# Rezoning Transportation Analysis

Petition Number: Insert Zoning Petition #2022-018

## Revision Log:

Date	Description
06-23-22	First Review (PDM)
07-20-22	Second Review (PDM)

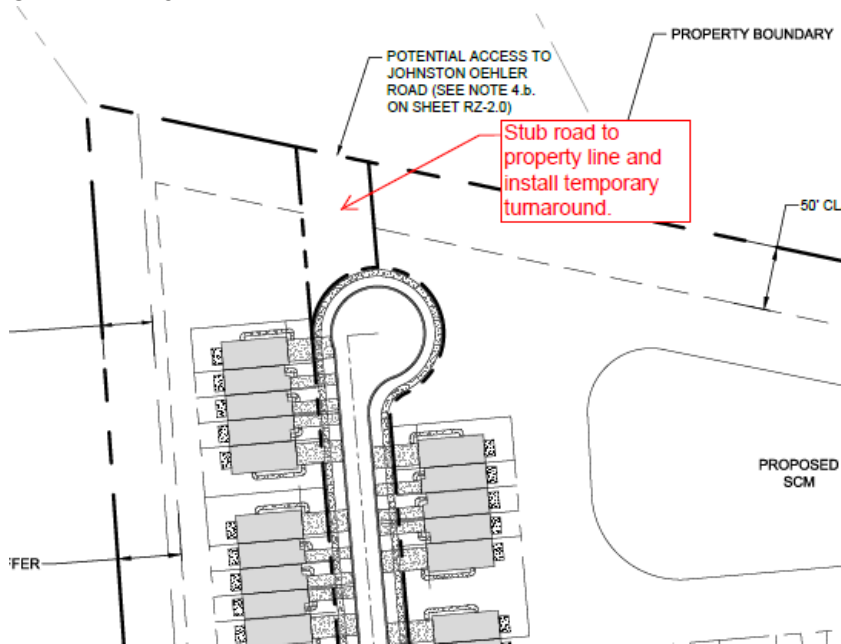
2. Revise site plan and conditional note(s) to identify the proposed streets and public or private. In addition, label each proposed street typical section per the CLDSM standard number on the site plan.

**Clarifying Comment (7-20-22):** Add a callout to each public road identifying the typical section per the CLDSM standard number on the site plan. In addition, update the typical sections to the latest version of the CLDSM typical section for these roadways. It should be revision 19 not 17.

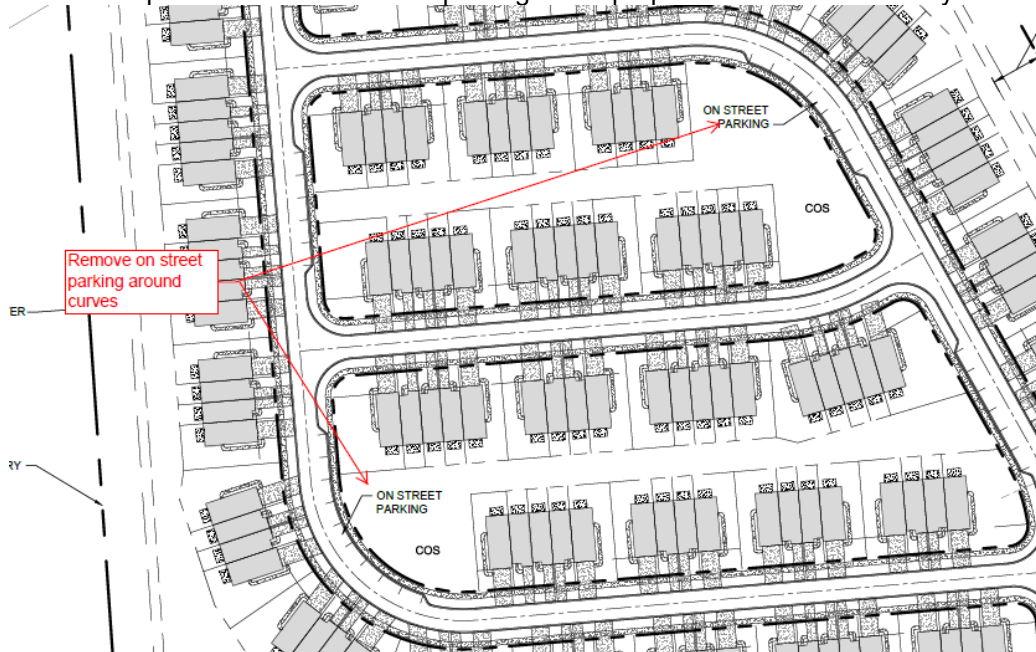
~~6. Revise site plan to stub the proposed street to the property line and install a temporary turnaround per CLDSM 11.18B.~~
